July 9, 2015

RE: 72 Bishop Street

Comments regarding the Draft Subdivision Plat

Title:
SUBDIVISION PLAT PLAN

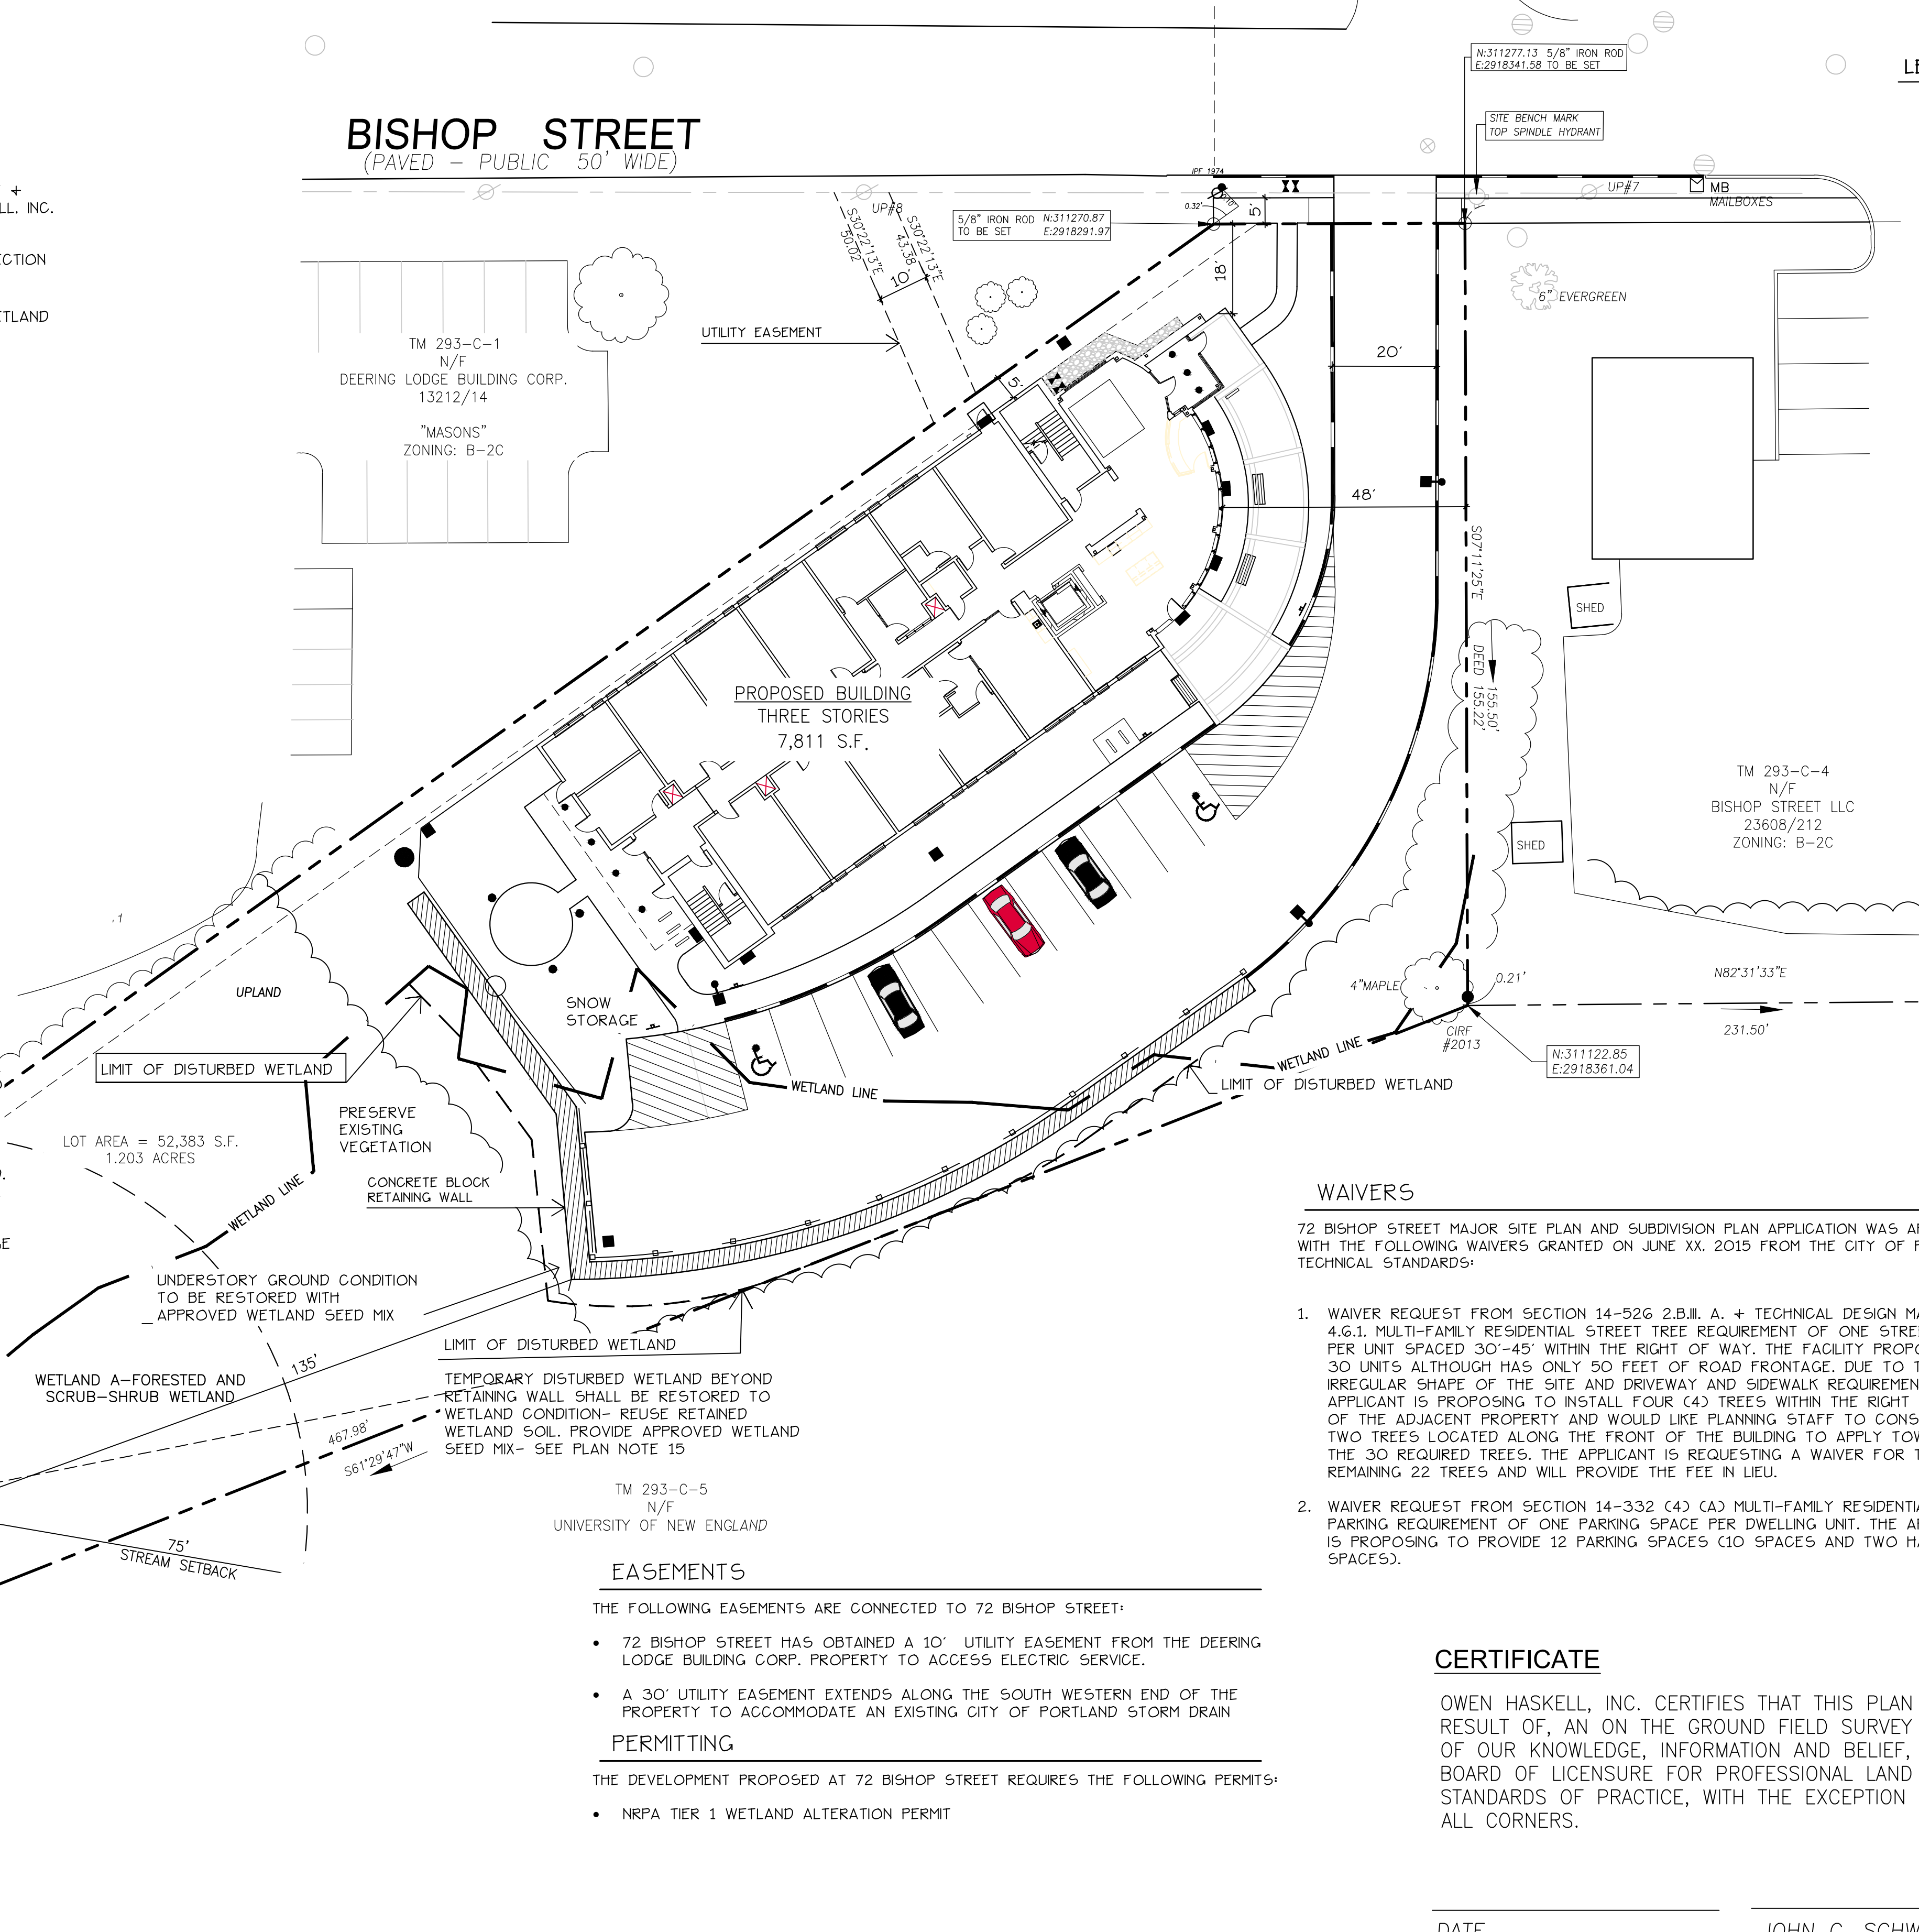
1. Add easements in graphic and list format.

Storm Drain Easement

The two utility easements have been labelled and noted on the plan.

*Regarding the storm drain easement area, we discussed with Mr. Clark that the easement area associated with the Bishop Street property will be limited to the area of the site impacted by the 15 FT off-set from the storm drain line. The extent of the easement on abutting properties will be the City's responsibility to obtain. **June 23, 2015***

The additional field survey documentation has been completed and shown on corresponding plans. We need to note that the existing manhole structure off site in the south east corner is buried and not accessible. This structure was previously located (not buried) by Owen Haskell, Inc. in 1974 for what was then Westbrook College. This is the location that was used in preparing the survey plan for 72 Bishop Street, all of the other structures were located. The easement has been located on the 72 Bishop Street property.
